Sent: 14 September 2023 09:47

Subject: RE: Consultation - 2023/92141 - Dewsbury Bus Station, Aldams Road, Dewsbury, WF12 8AR

Drawing  
Proposed Elevations Sheet 1

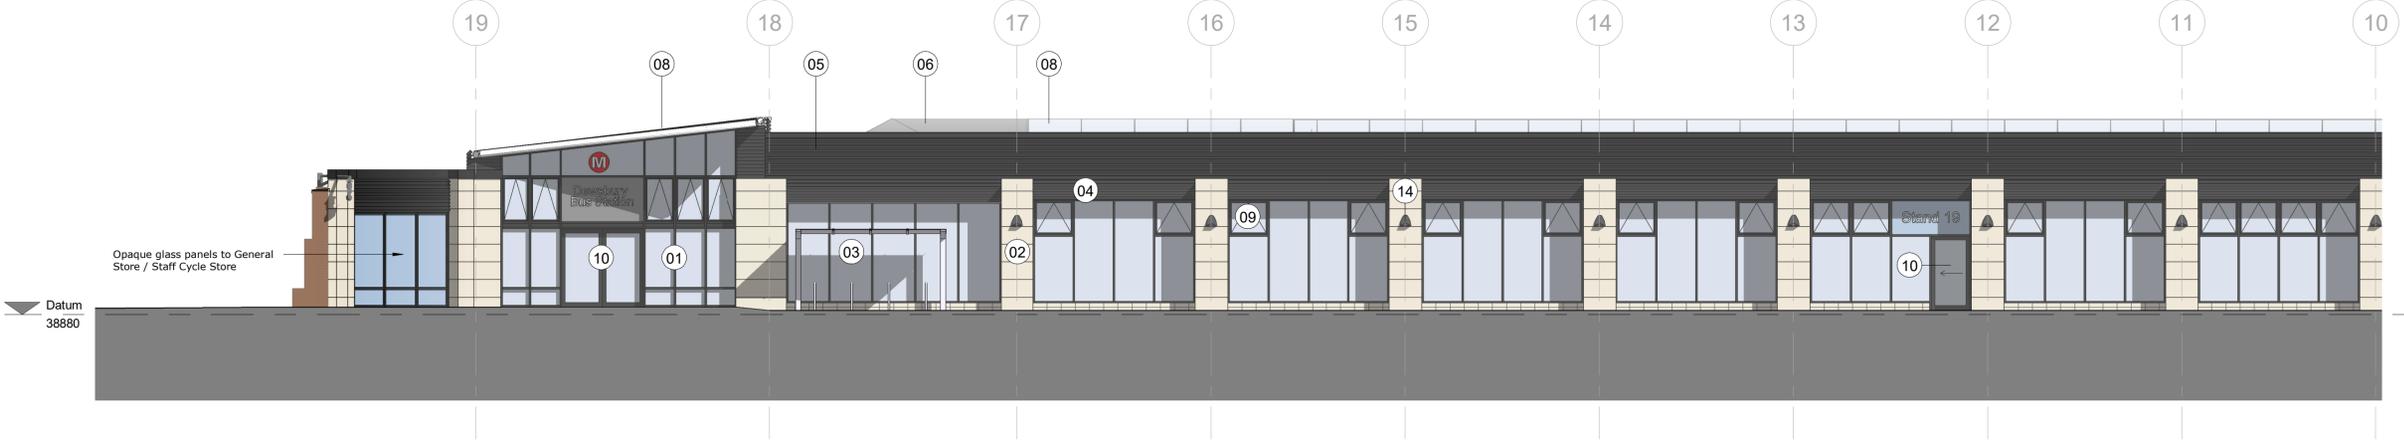
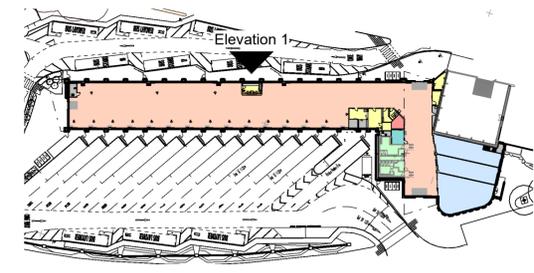
We would raise no concerns in regard to the proposed design, which appears well-considered. There is however one element which we consider needs amending. The plans state that the proposed stone cladding will be composite stone. We would advise that this should be amended to be natural stone. We consider that this will enhance the overall design.
